**KIRKLEES METROPOLITAN COUNCIL  
INVESTMENT & REGENERATION SERVICE**

**DELEGATED DECISION FOR APPLICATION FOR CERTIFICATE OF  
LAWFUL DEVELOPMENT**

Reference no.: 2024/CL/92470/W

Description: Certificate of lawfulness for proposed erection of  
single storey rear extension

Drawing No  
 PL02

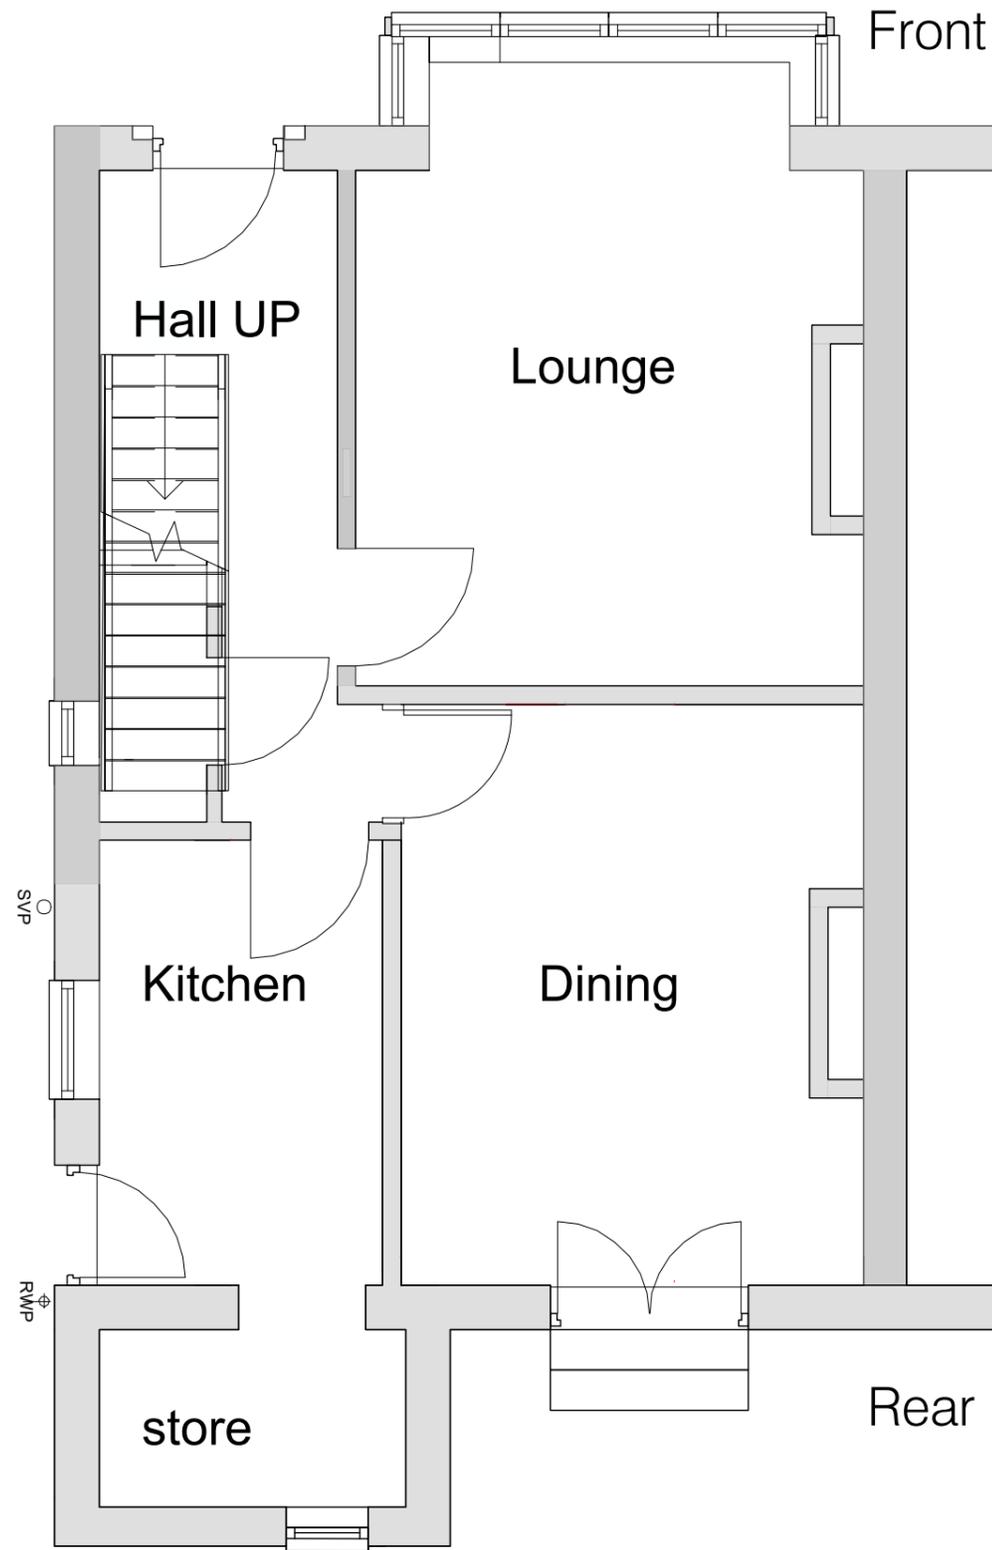
**Comment:** *The Council's earliest ordnance survey historic map dated 1961 indicate the dwellinghouse featured a rearward projection to the north east corner of the rear elevation. Other similar properties within the immediate area also contain a similar feature and as such it is considered the original dwellinghouse was constructed with the rearward projection and thus part of the original dwellinghouse. The projection therefore consists of a wall which forms a side elevation of the original dwellinghouse. The proposed enlargement extends beyond the entire width of the dwellinghouse and therefore the enlarged part of the dwellinghouse extends more than half the width of the original dwellinghouse.*

Drawing No
 PL03

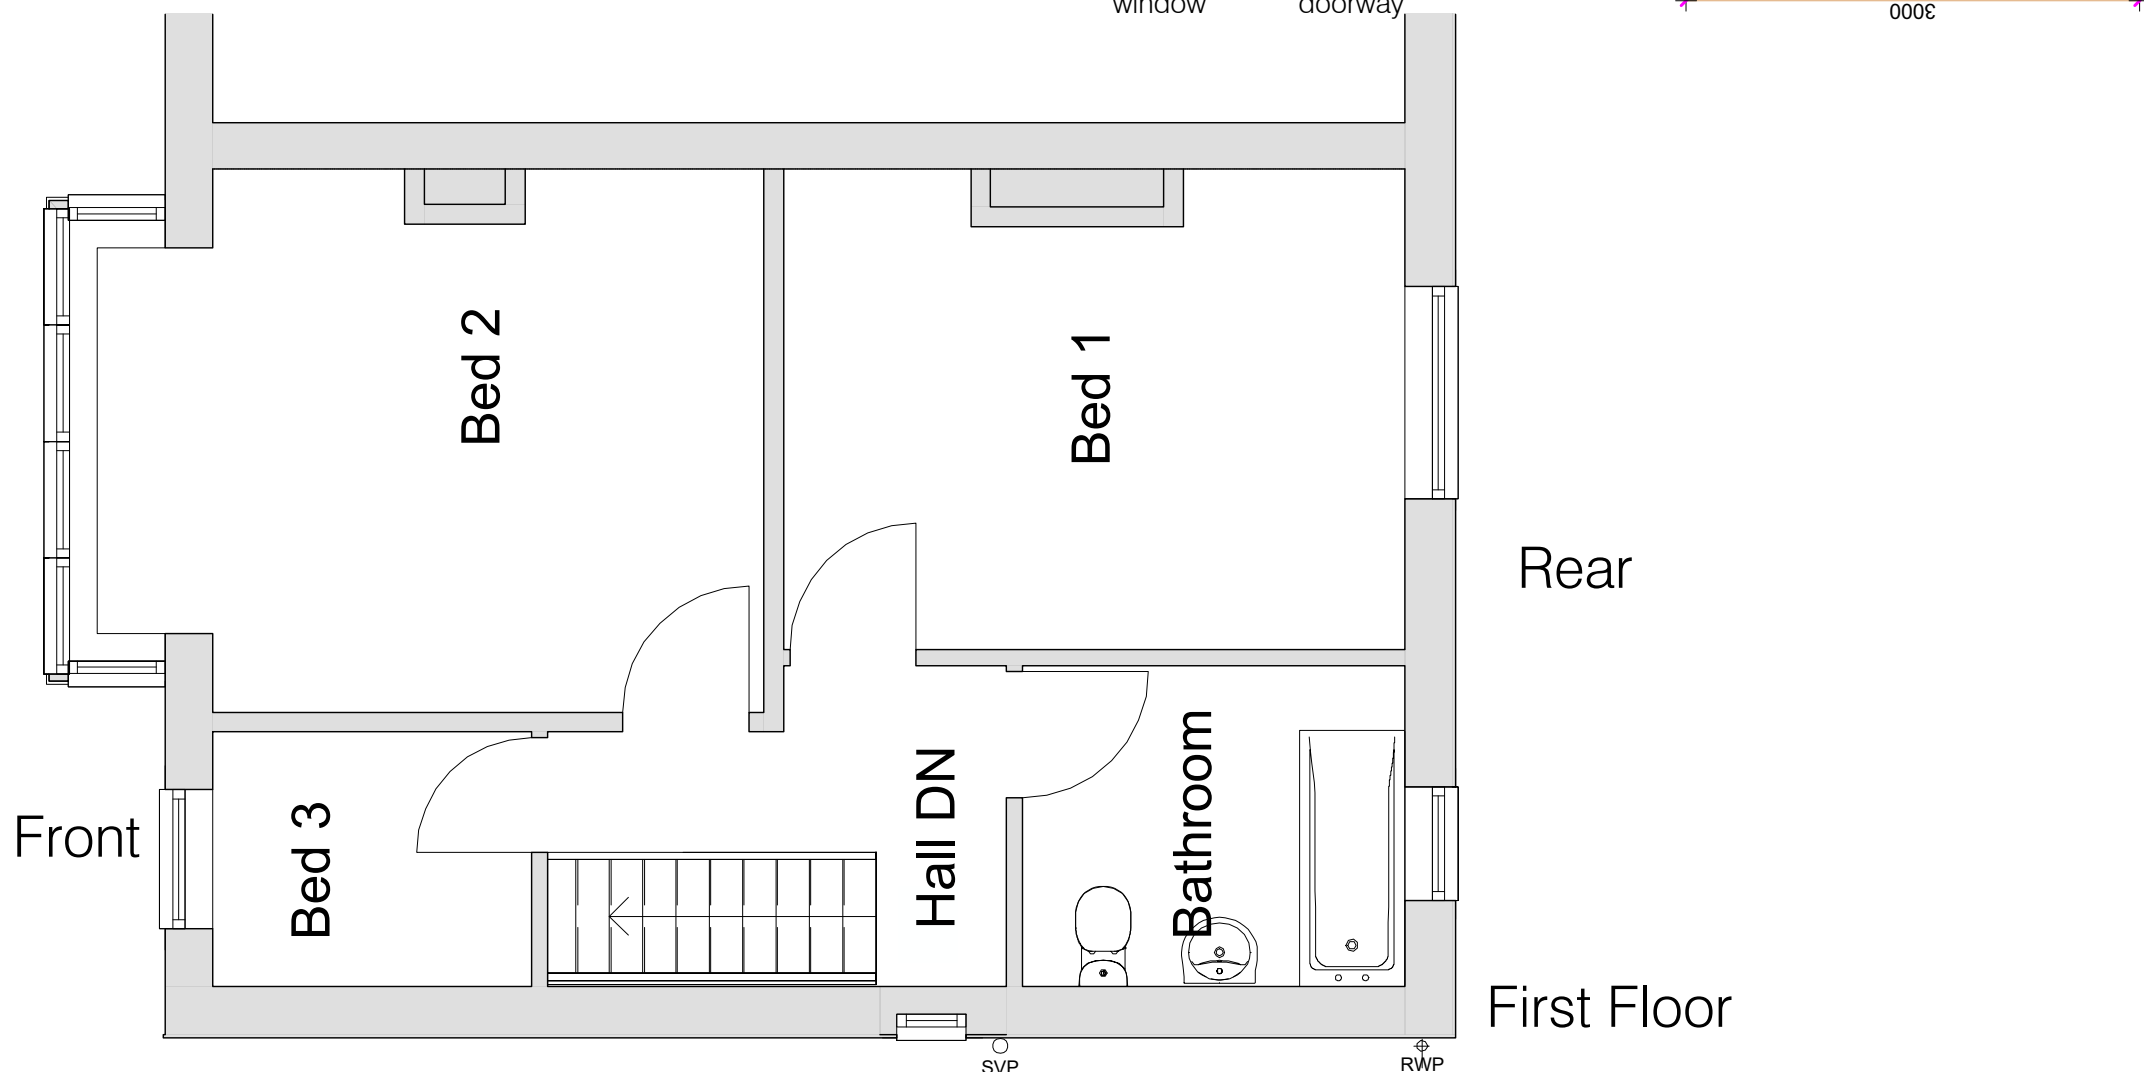
The proposed rear storey extension would not benefit from a general planning permission granted by virtue of Article 3(1) and Schedule 2, Part 1, Class A of the Town and Country Planning (General Permitted Development) (England) Order 2015 (as amended) as the proposed enlarged part of the dwellinghouse extends beyond a wall forming a side elevation of the original dwellinghouse contrary to sub-paragraph A.1(j) of Class A.
